**CITY OF ALBUQUERQUE
PLANNING DEPARTMENT
April 15, 2015
DRB Comments**

PROJECT # 1010440

RE: Lots 22-24, Block 3, Emil Mann Addition

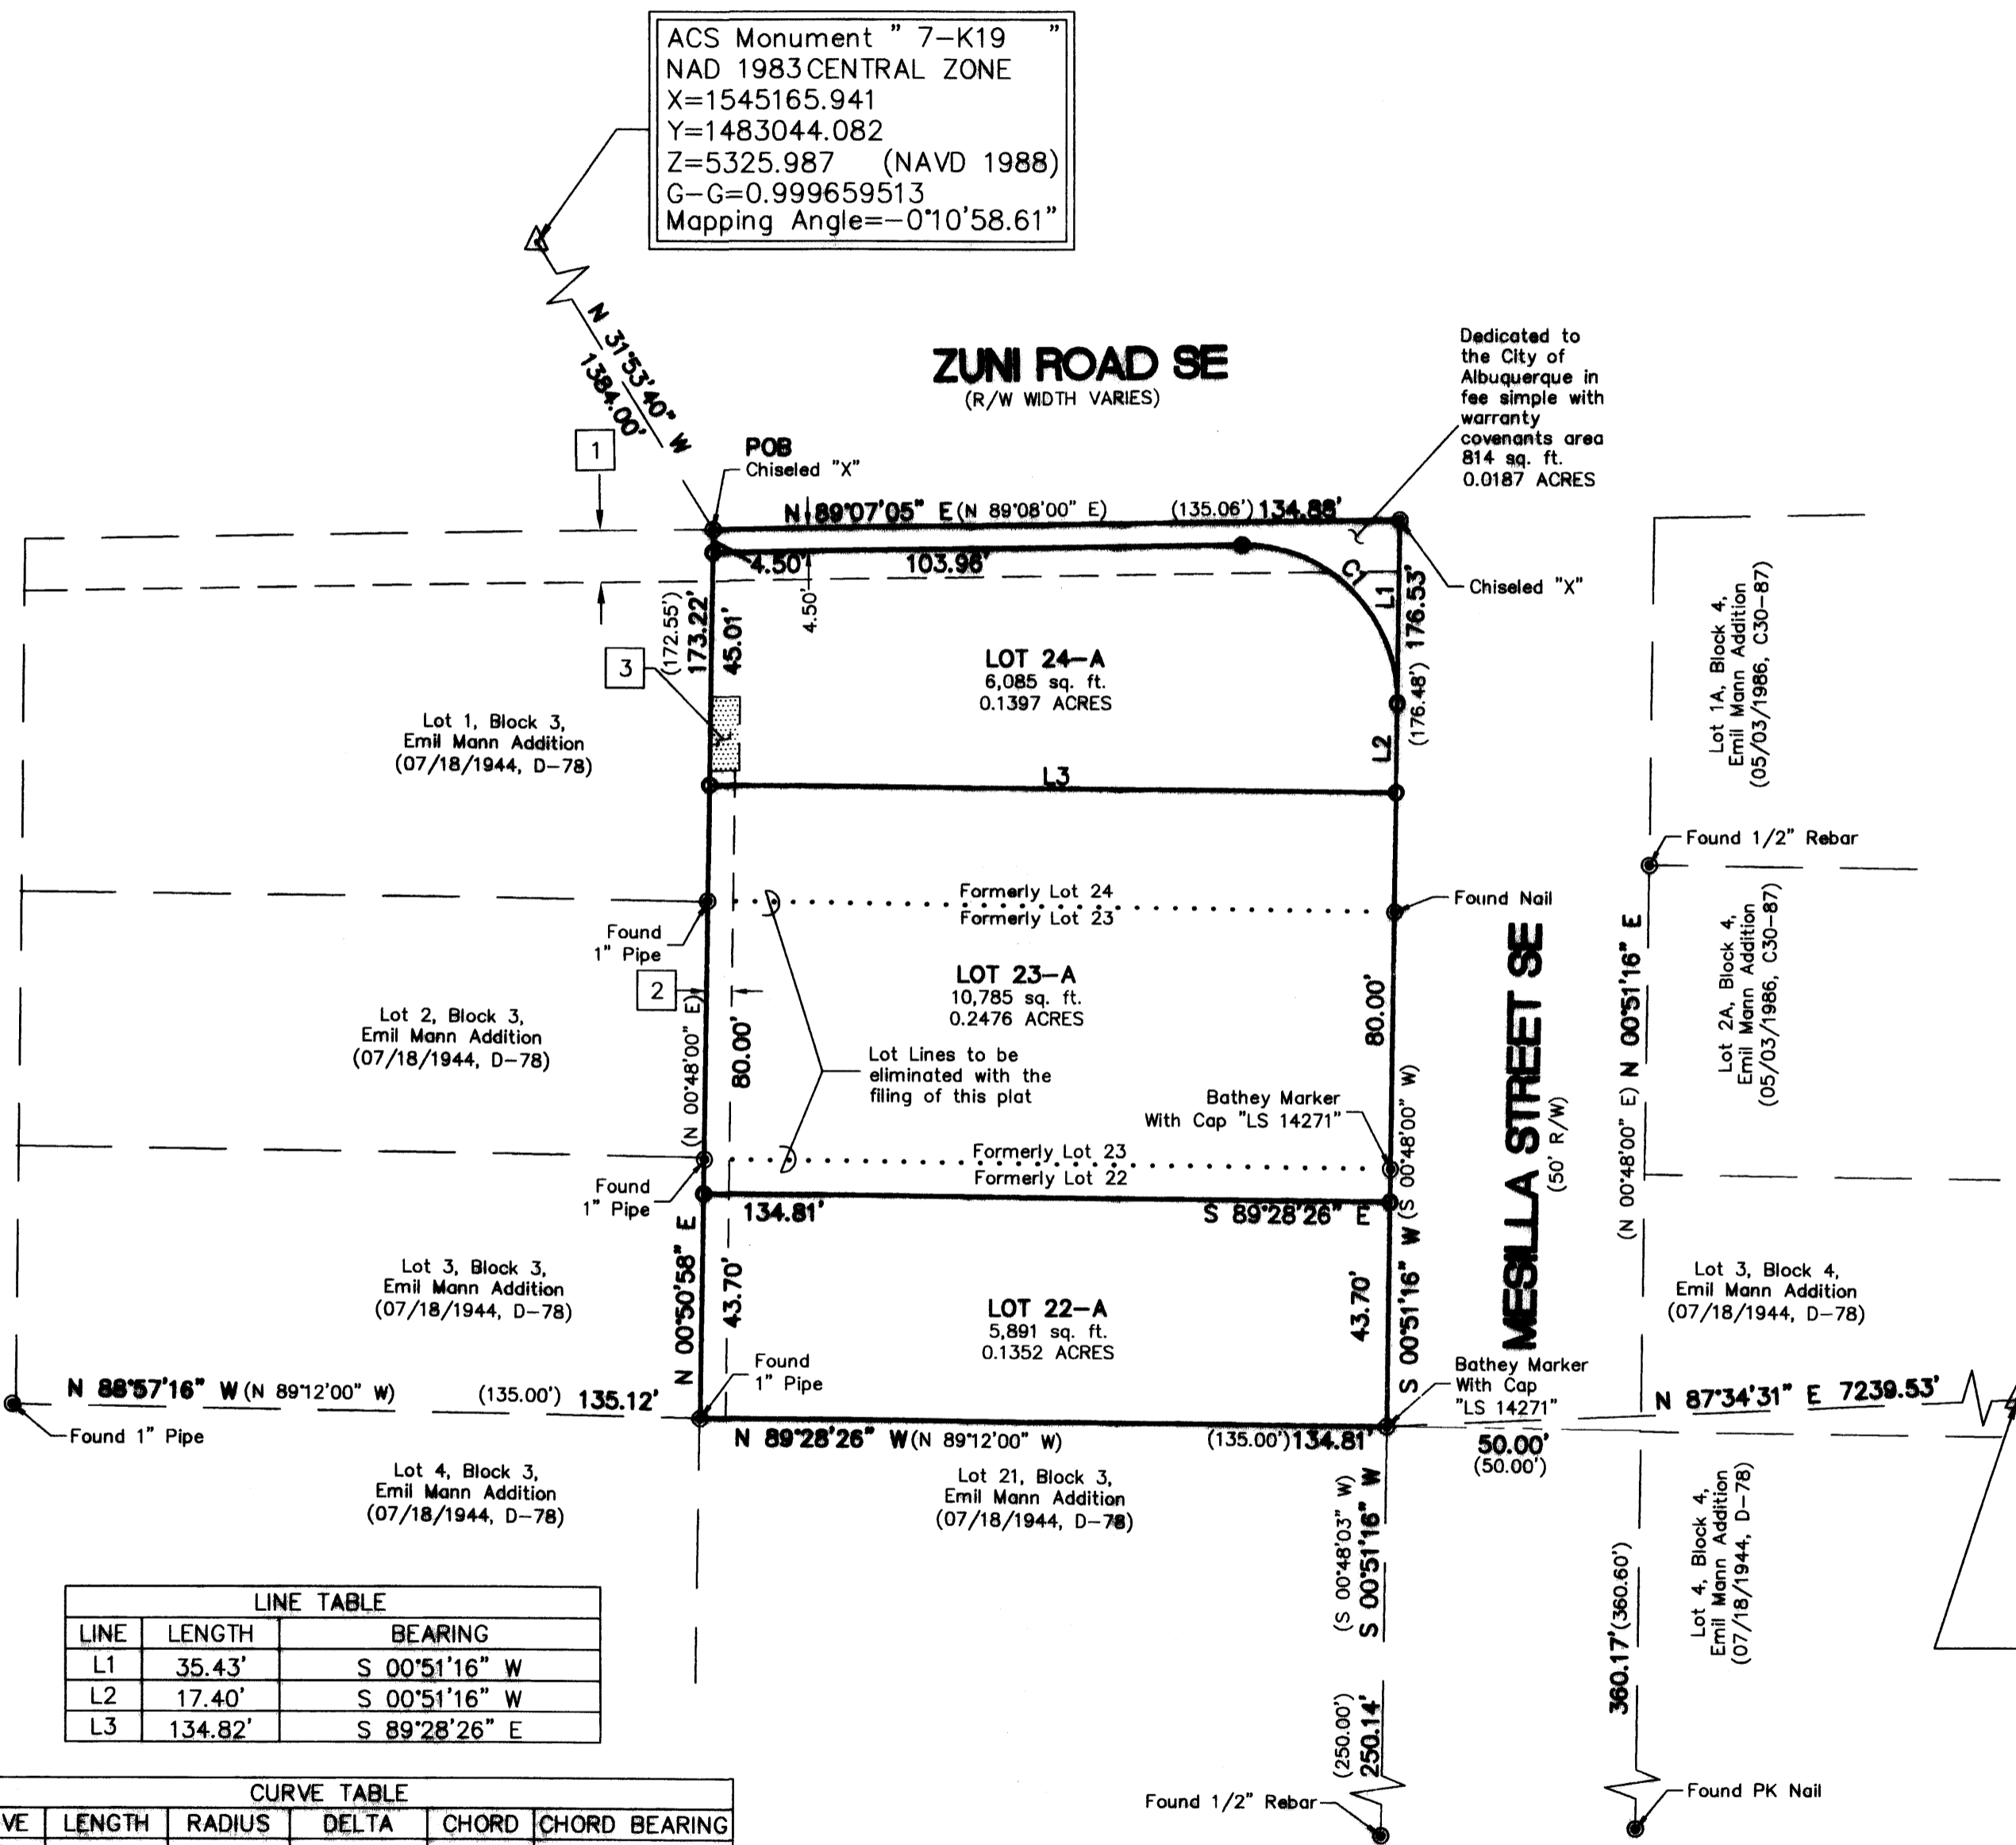
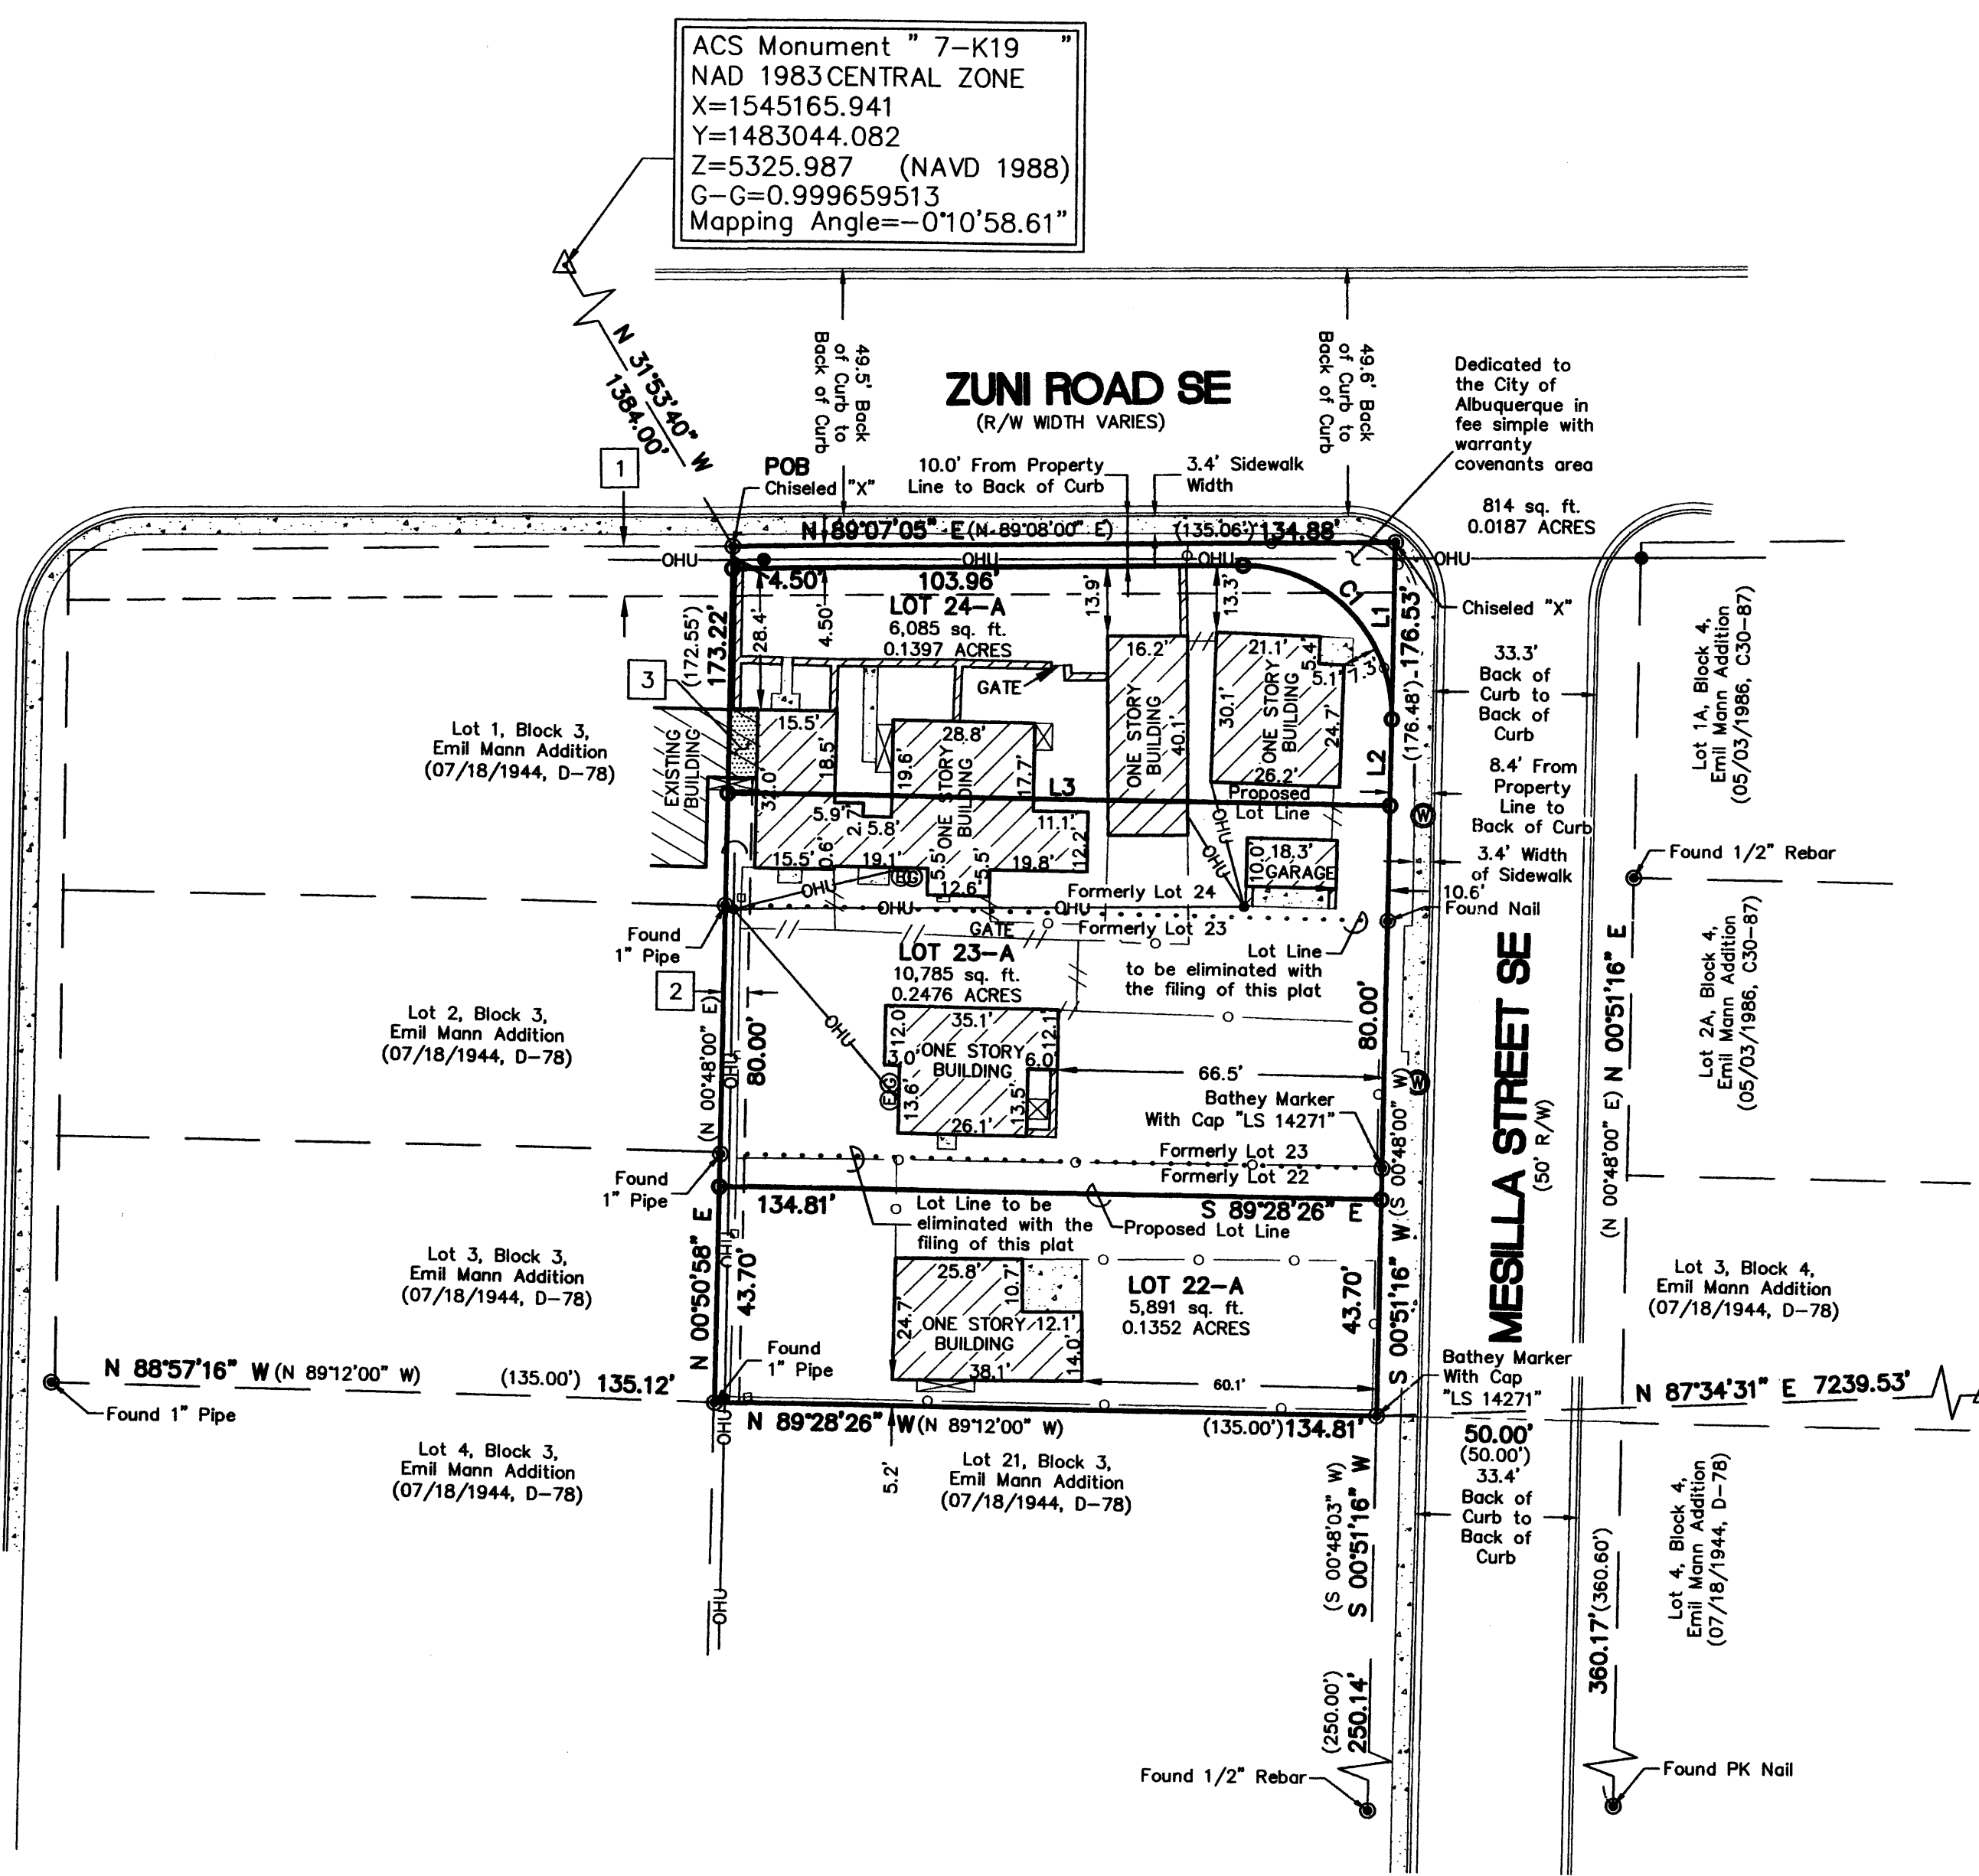
If Note 3 on Sheet 2 is for a building encroachment, an Easement Agreement is not adequate for platting. The property to the west either needs to be involved with the plat or the owner of that property will have to modify their building such that it conforms to the Building Code, as will all buildings which are to remain..
